**Planning Application Ref:** WA/84/16/PL (3) – revised comments added in red (reviewed 6<sup>th</sup> March 2017).

**Location:** The Red Cottage, The Street, Walberton

**Description of works:** Construction of a two storey house in the front garden of Red Cottage – revised frontage layout

Consultant Arboriculturist

Date	Drawn	Scale	Check
Sept 18	DC	1:1250, 1:500, 1:200@A3 MW	
Job Number	Prefix	Drawing Number	Revisk
16035	P	100	C

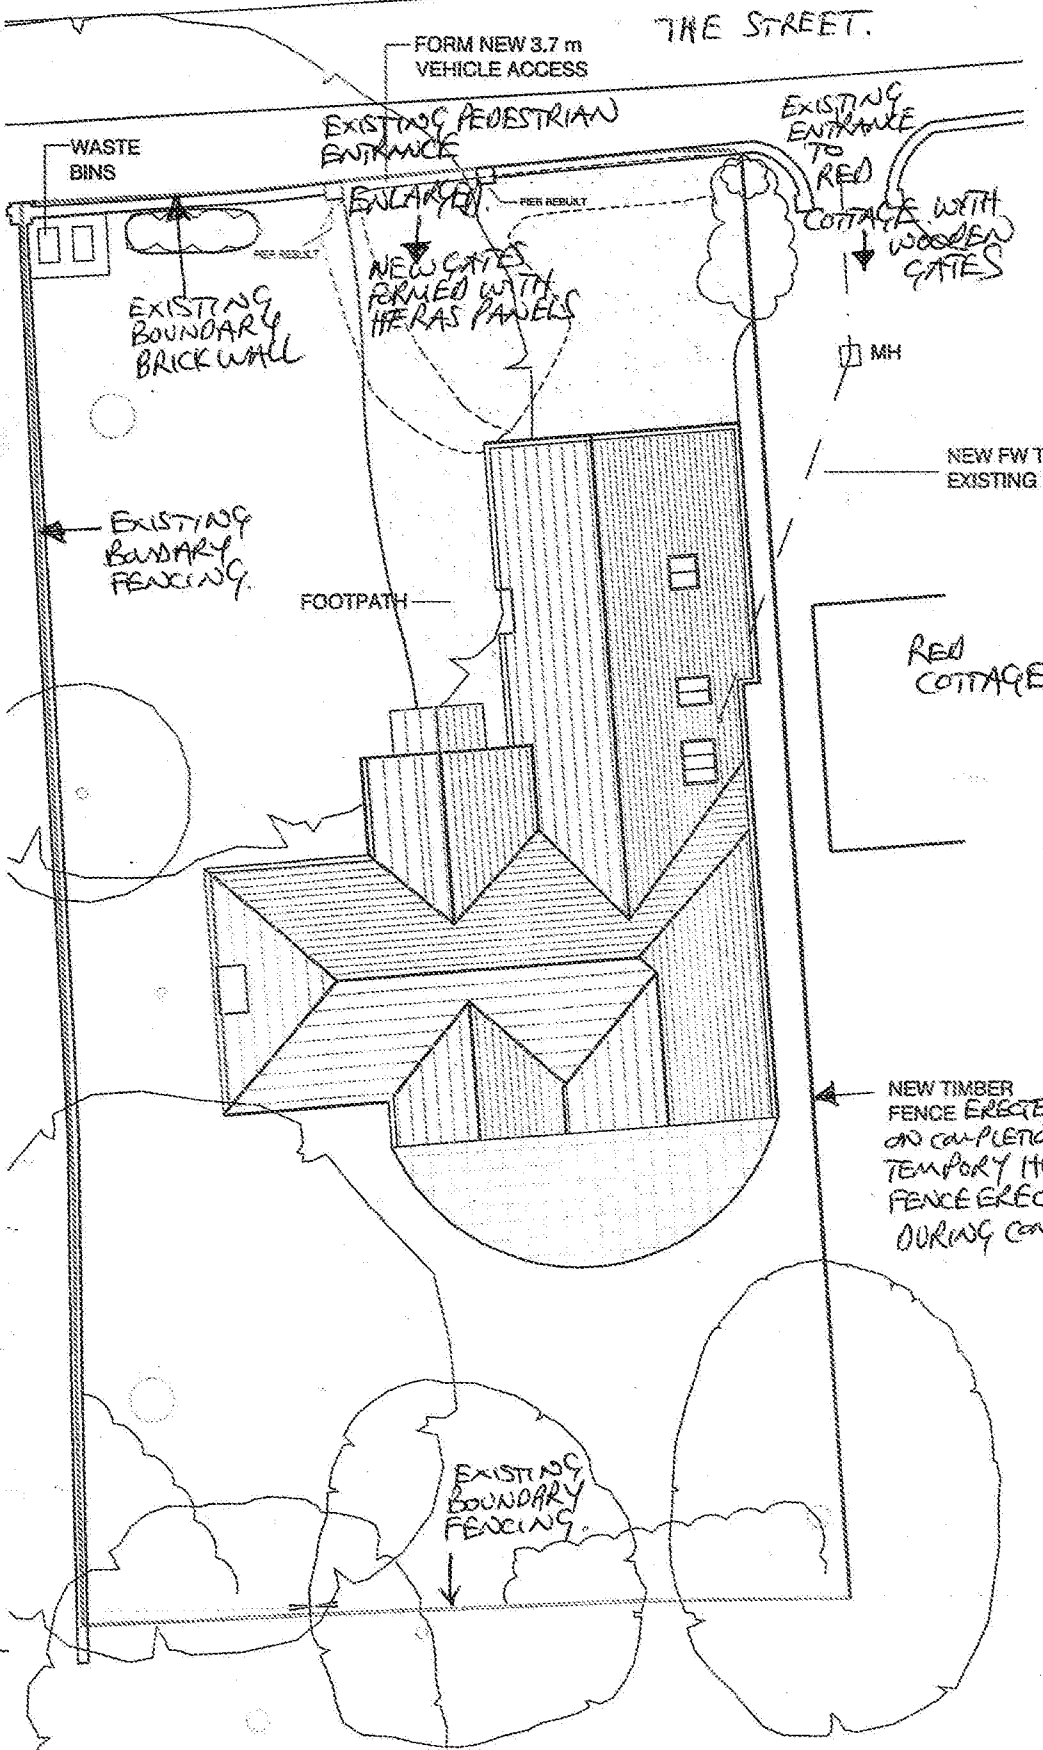
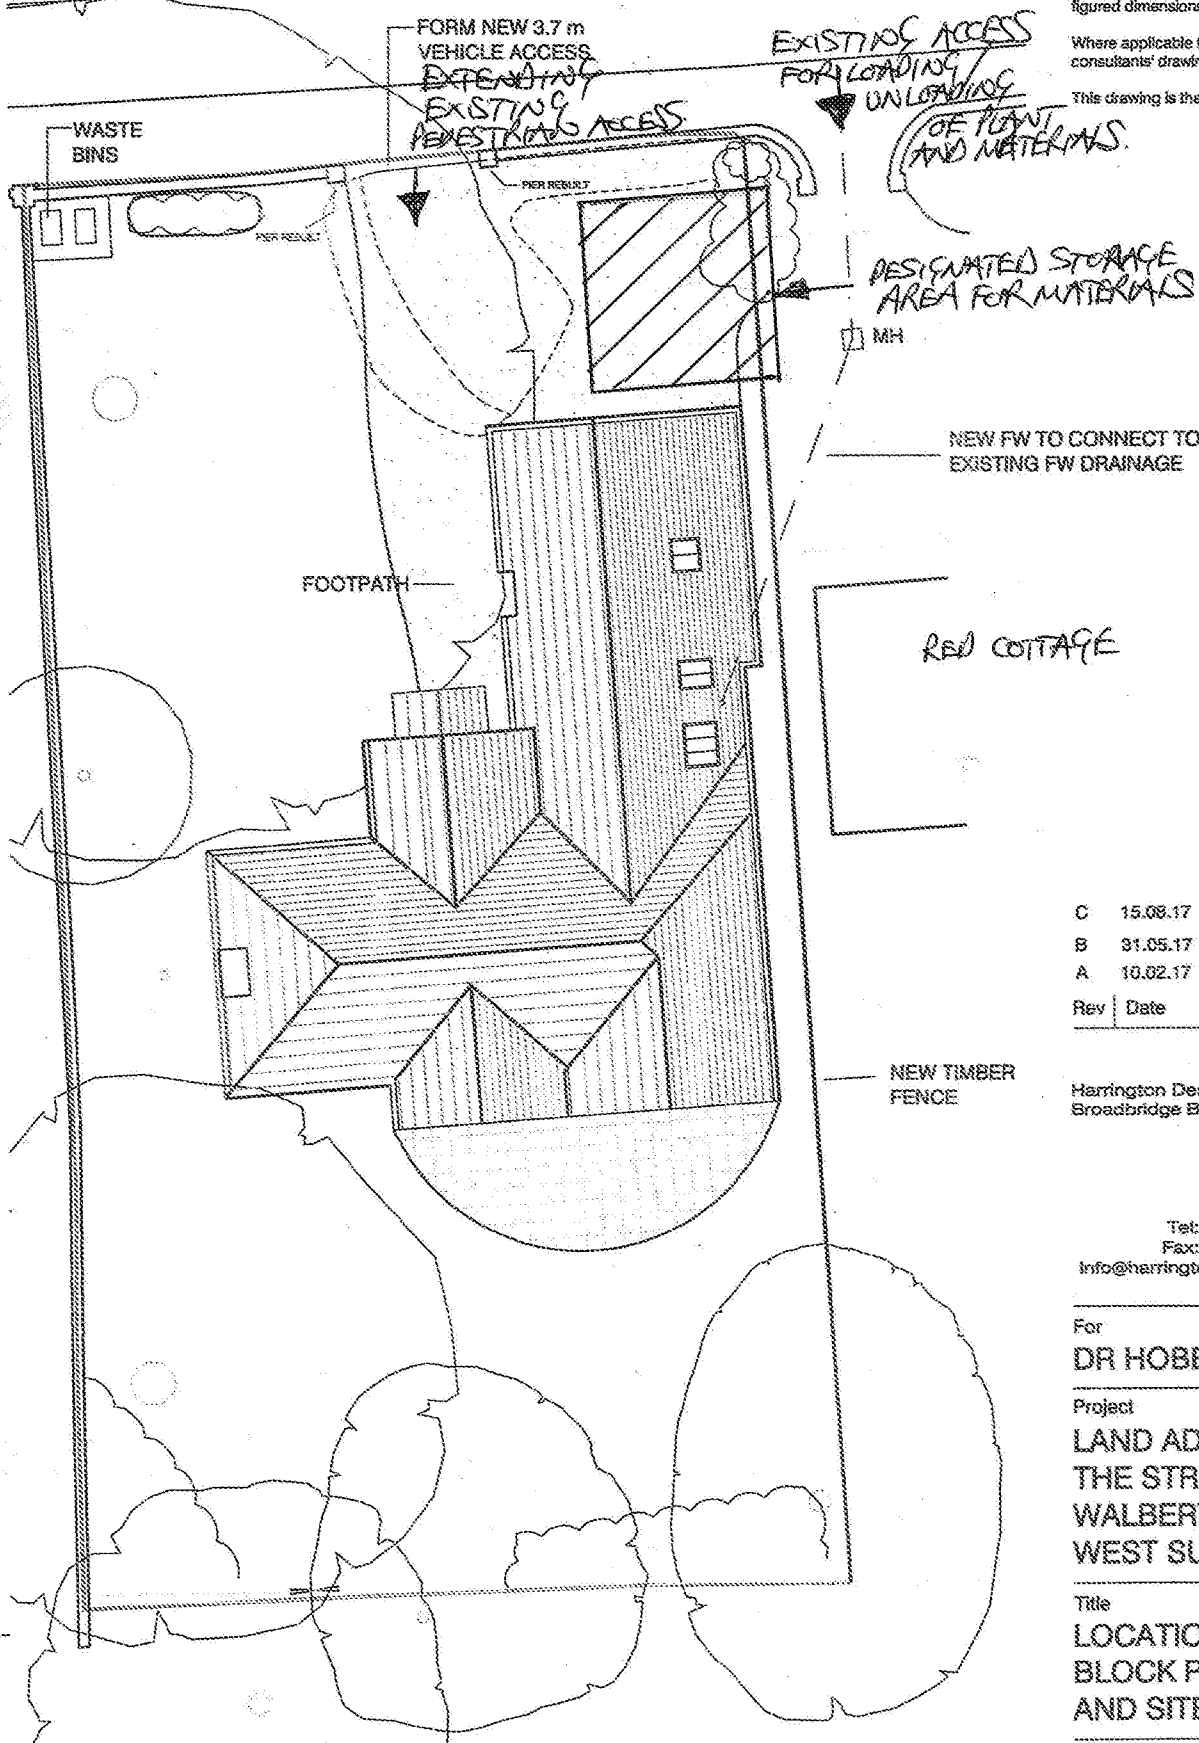
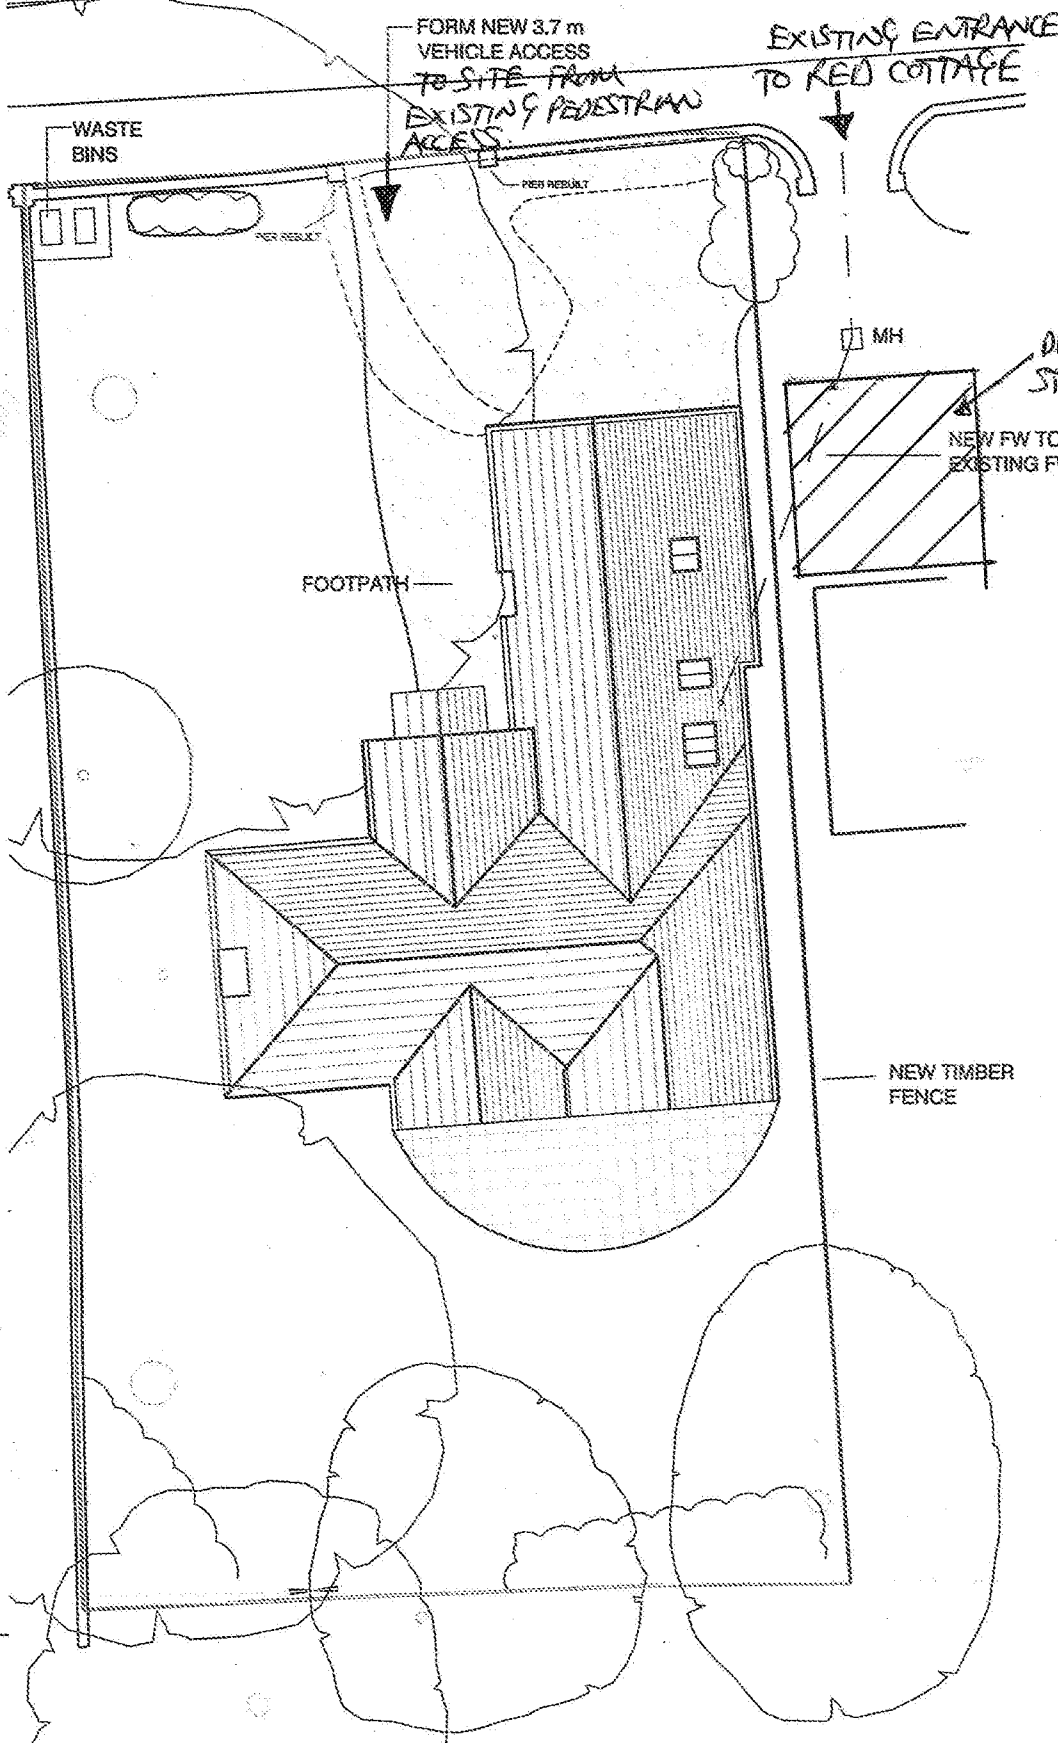
- I sustain all of my comments made previously especially those in blue – I found the previous frontage layout 16035-P-100-Rev B to be just about acceptable BUT this new layout 16035-P-Rev C will have a significant detrimental impact to the vigour and vitality of the TPO’d Oak at the front of the property and I would wish to see cross section drawings and methodology to explain how they see this being installed without damaging tree roots.

2. I remain to be convinced that access can be provided for a footpath link to the pavement and hard surfacing for car parking and turning head in front of the garages without excavation given the steep slope and differences in levels from inside the site to street level – under these circumstances I believe that significant root damage would be incurred to the detriment of the ongoing vigour and vitality of the frontage Oak. I suggest that cross section drawings are prepared through the footpath route and also through the hard standing/garages to show the existing and proposed levels and for the applicant to prove that this can be resolved without detriment to the tree. **Issue resolved. This issue is now back to a situation where I believe significant root damage will be caused to the TPO'd Oak and I therefore OBJECT to the new layout.**
